DECISION DELEGATED TO HEAD OF PLANNING

Application No: H08-0145-26 **Applicant:** Mr & Mrs A Wilde
Proposal: Replacement of entire roofing slates along with new guttering
Location: 57 - 59 Salem Street Gosberton Spalding
Terminal Date: 7th July 2026

DRAWING TITLE
Proposed Details

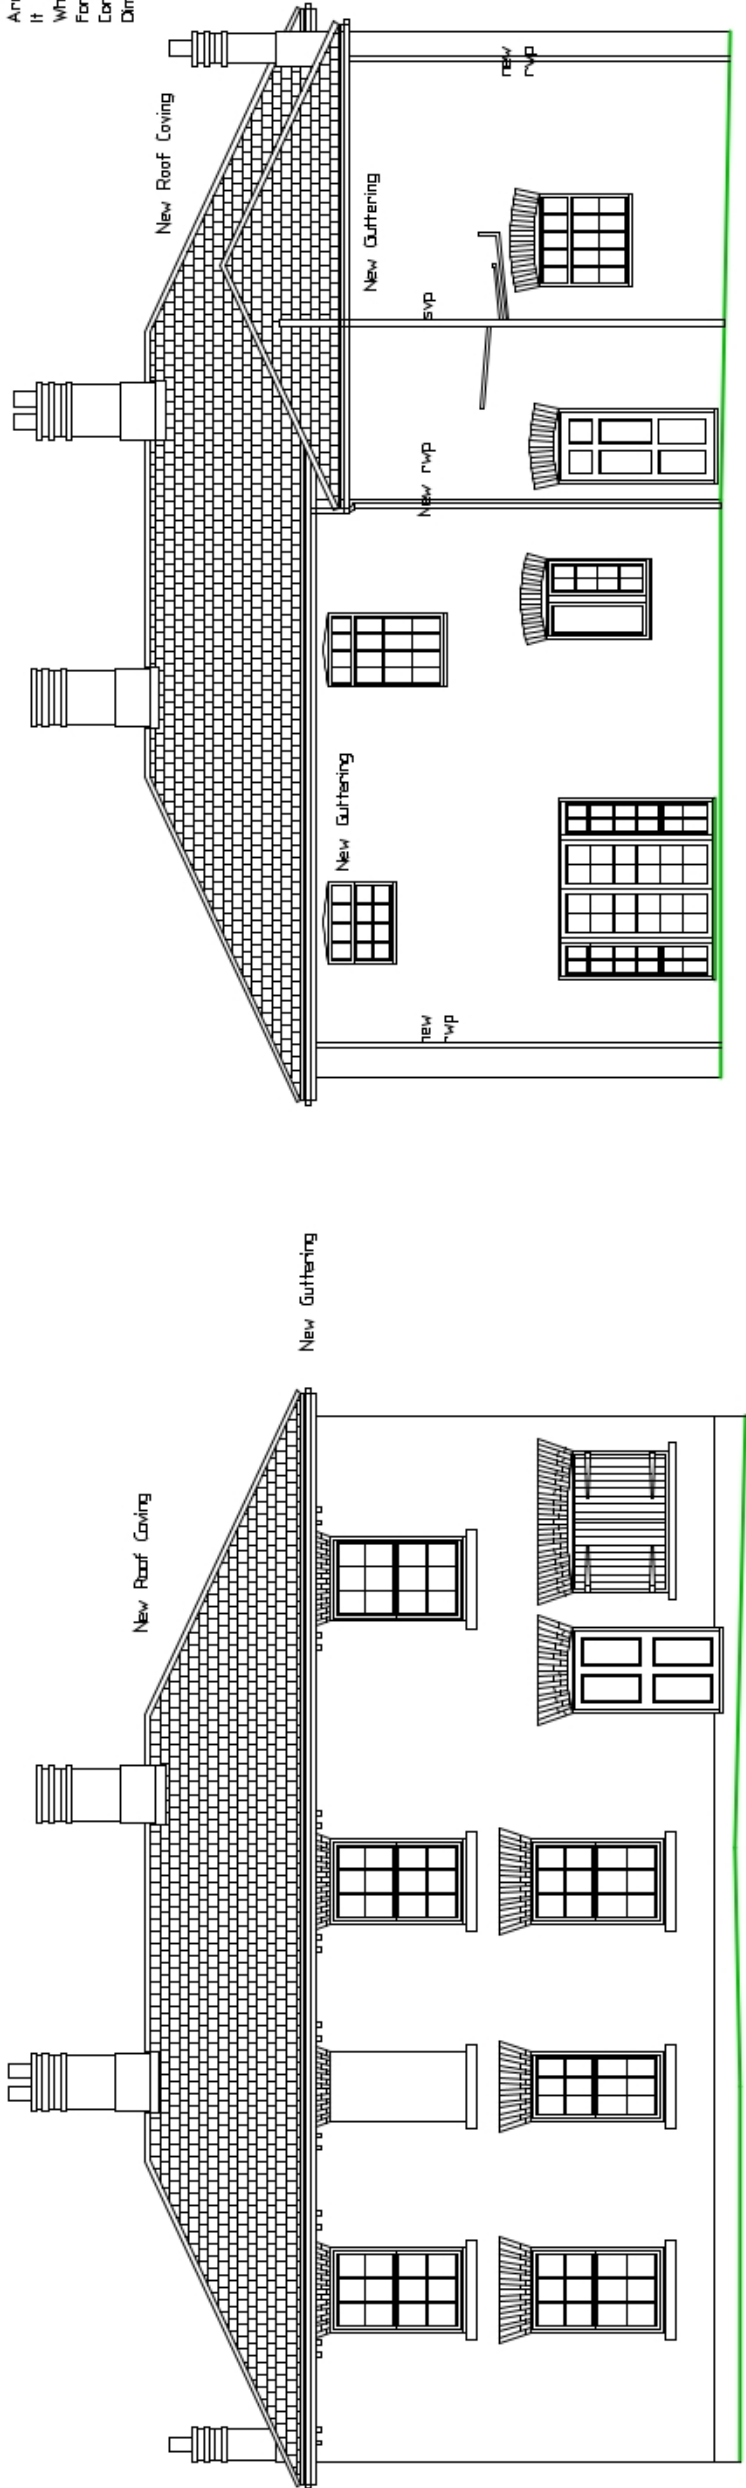
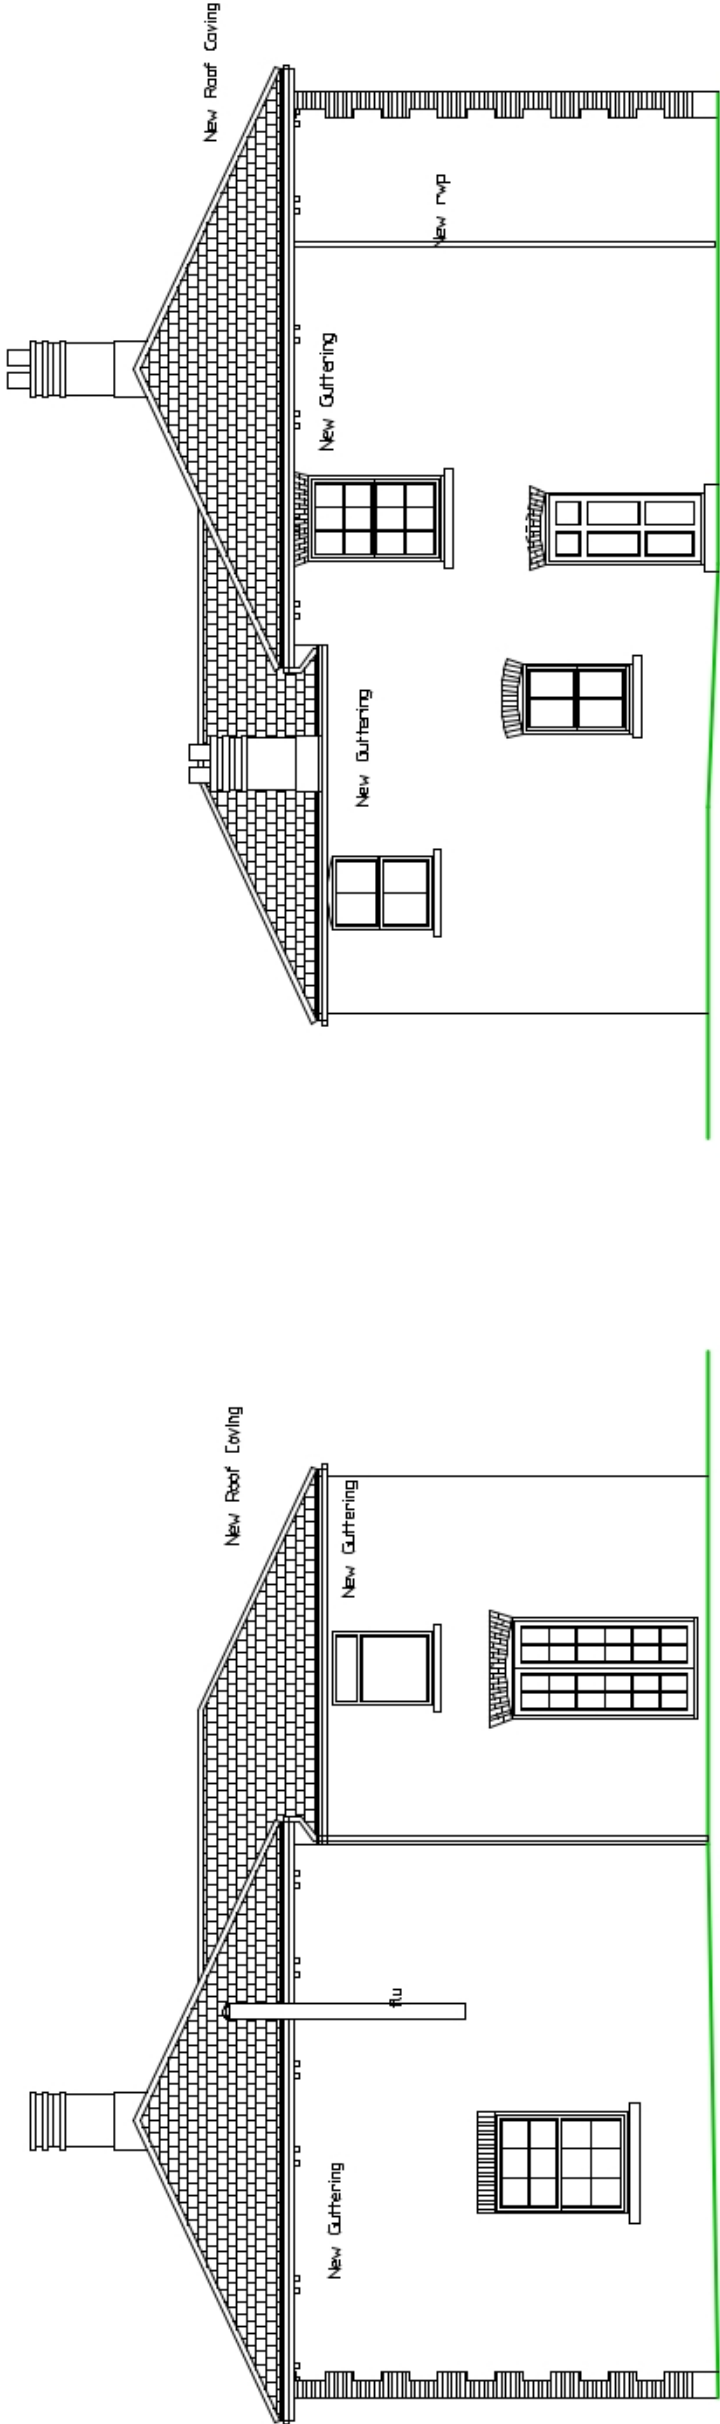
In assessing this proposal, the application fails to meet any of the above requirements. The applicant seeks to replace vernacular, authentic slate roofing material with fibre cement alternatives and historic, vernacular metal rainwater goods with plastic modern alternatives. The applicant is reminded (per the above) that this is a prominent and important NDHA making a clear and evidenced contribution to the setting of a Designated Heritage Asset (the GCA). The existing metal RWGs and authentic, natural slate tiles are not of poor quality, nor do they detract from the character and appearance of the site. We do not consider that fibre cement slates or plastic RWGs represent a form of preservation or enhancement of the historic environment. In fact, they do not sufficiently replicate the appearance of an authentic product, and as such, I consider their introduction to actually represent a form of harm.

Therefore, I consider these proposals to represent a form of less than substantial harm to the setting of the GCA and the article 4 property. Such harm is not sufficiently justified in the applicant's statement. Damage to the internal roof structure relating to non-associated prior works is not justification for the total loss of an exterior architectural and material feature. Neither is the existence

of some sections of PVC RWGs justification for the wholesale removal of the remaining high quality metal products to be replaced with visually and materially inferior PVC units. Moreover, subject to P.215 of the NPPF, there is no public benefit against which to weigh the harm, as this is a privately owned property and thus any benefits are borne solely by the property owner and not the public.

The proposal would see the loss of a traditional, vernacular material with a fibre cement imitation. These fibre cement products weather differently from natural slate, leading to the imitation weakening over time. This in turn erodes the historic character of the building and area. Moreover, the fibre cement products have a smoother appearance which lacks the variation and character of a natural slate. Whilst slate is not ubiquitous in the area, it is currently present on the property, and appears to be the material used traditionally on the site.

Likewise, the proposed "Bret Martin Cast Looking Guttering" imitates a traditional style, but will naturally age differently to traditional metal guttering. That being said, it must be acknowledged that some plastic products are already present on site, and this must be considered when judging the relative impact.

The proposal, taken as a whole, is considered to introduce non-traditional materials, which would harm the appearance of the non-designated heritage asset and the wider Conservation Area, particularly in the medium to long term as differences in expected weathering patterns materialise. In this instance, less than substantial harm is identified, in line Paragraphs 215, 216 and 220 of the NPPF. The view of less than substantial harm is consistent with that of the Conservation Officer, who's comments can be found above.
